Rezoning Transportation Analysis

Petition Number: #2022-161

Date	Description
02-23-23	First Review (PDM)

SHEET NO.	SHEET NAME
1 of 3	CONCEPTUAL SITE PLAN
2 of 3	TECHNICAL DATA
3 of 3	MASTER PLAN

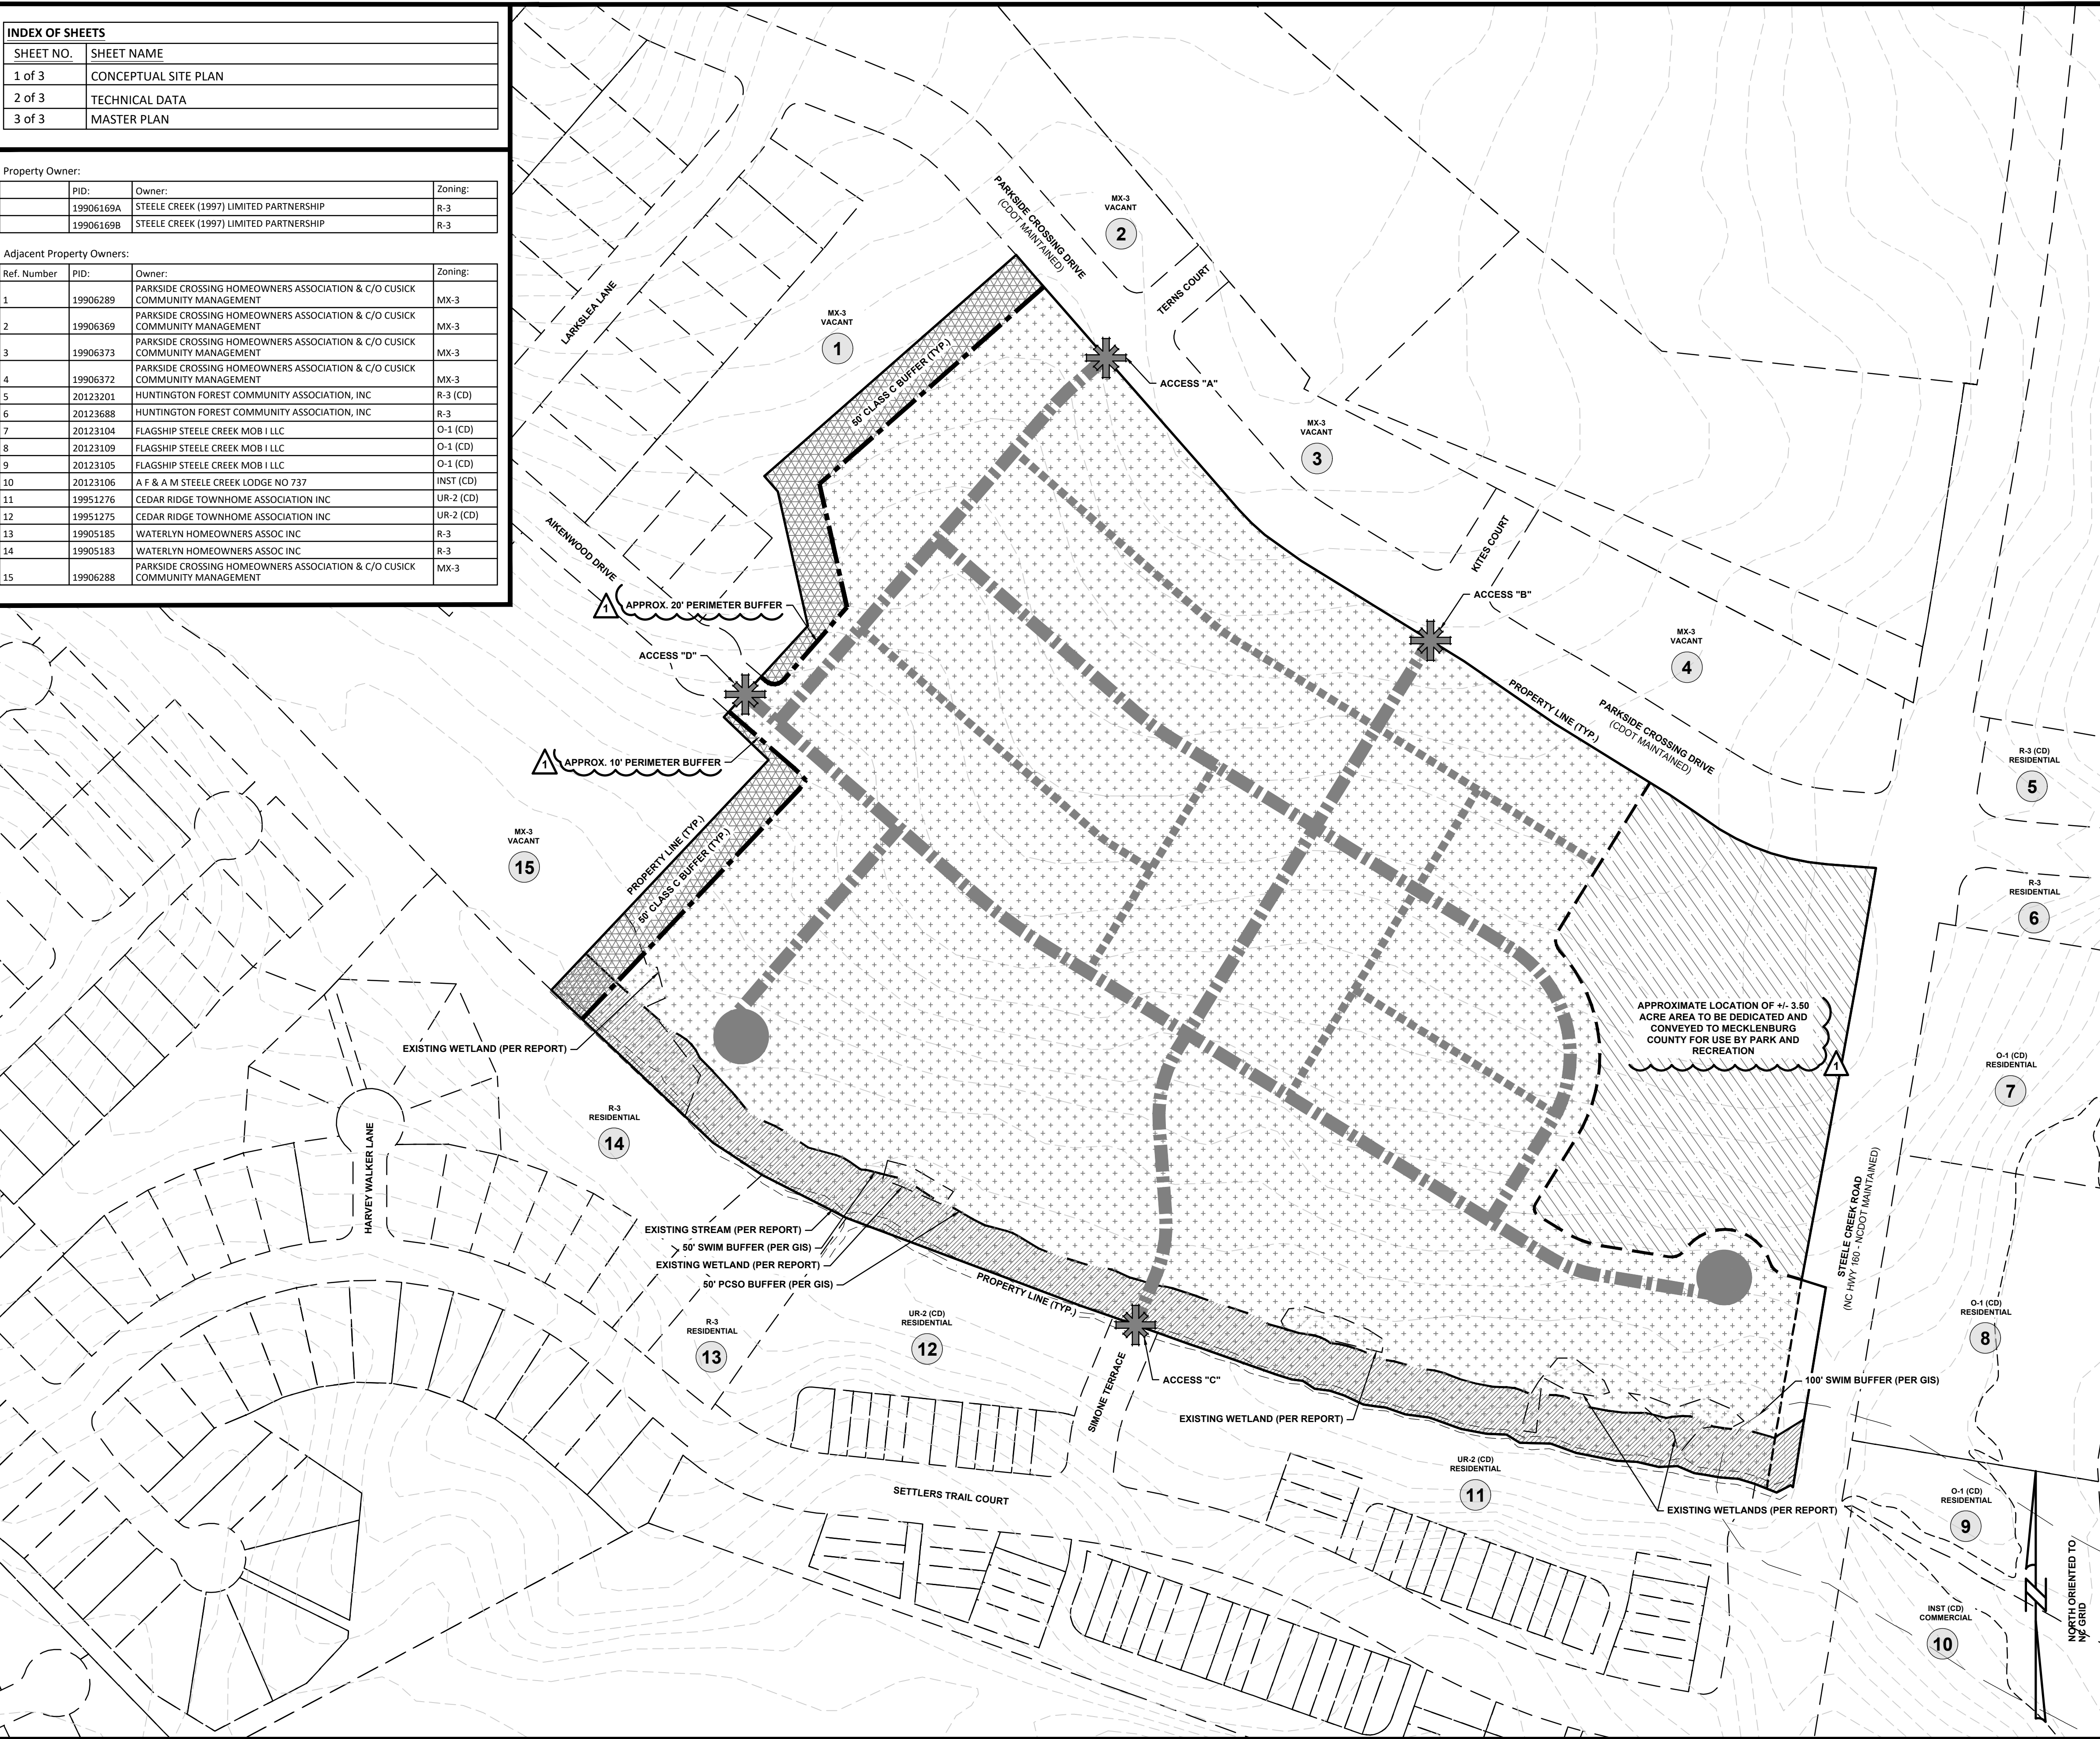
- a. **Steele Creek Road:** Location of the future curb and gutter to be installed at 33 feet from roadway centerline to accommodate the Charlotte Streets Map roadway typical section of four plus lane avenue with shared use path. The future curb and gutter should be shown on the plan and dimensioned from the centerline.

- b. **Parkside Crossing:** Location of the future curb and gutter to be installed at 17.5 feet from roadway centerline to accommodate the Charlotte Streets Map roadway typical section of collector street per CLDSM U-07. The future curb and gutter should be shown on the plan and dimensioned from the centerline.

Label and dimension the curb and gutter from the centerline for each road on the site plan.

3. Revise site plan and conditional note(s) to commit to dedicate all necessary ROW and easements along Steele Creek road for the NCDOT U-5766B project.
4. Revise site plan and conditional note(s) to show the previously approved sidewalk and the curb and gutter along Parkside Crossing.
5. Revise site plan and conditional note(s) to commit to construct bicycle facilities by installing a 12' multi-use path to meet the Council-adopted Charlotte BIKES Policy. Multi-use paths maintained by the City shall meet ADA/PROWAG requirements.
6. CDOT REQUEST: Revise site plan and conditional notes to commit to providing a 12-ft multi-use path connection from the proposed cul-de-sac to the proposed MUP along Steele Creek

7. Revise site plan and conditional notes to commit to removing the existing turnaround on Aikenwood Drive at the proposed Access D Street connection.
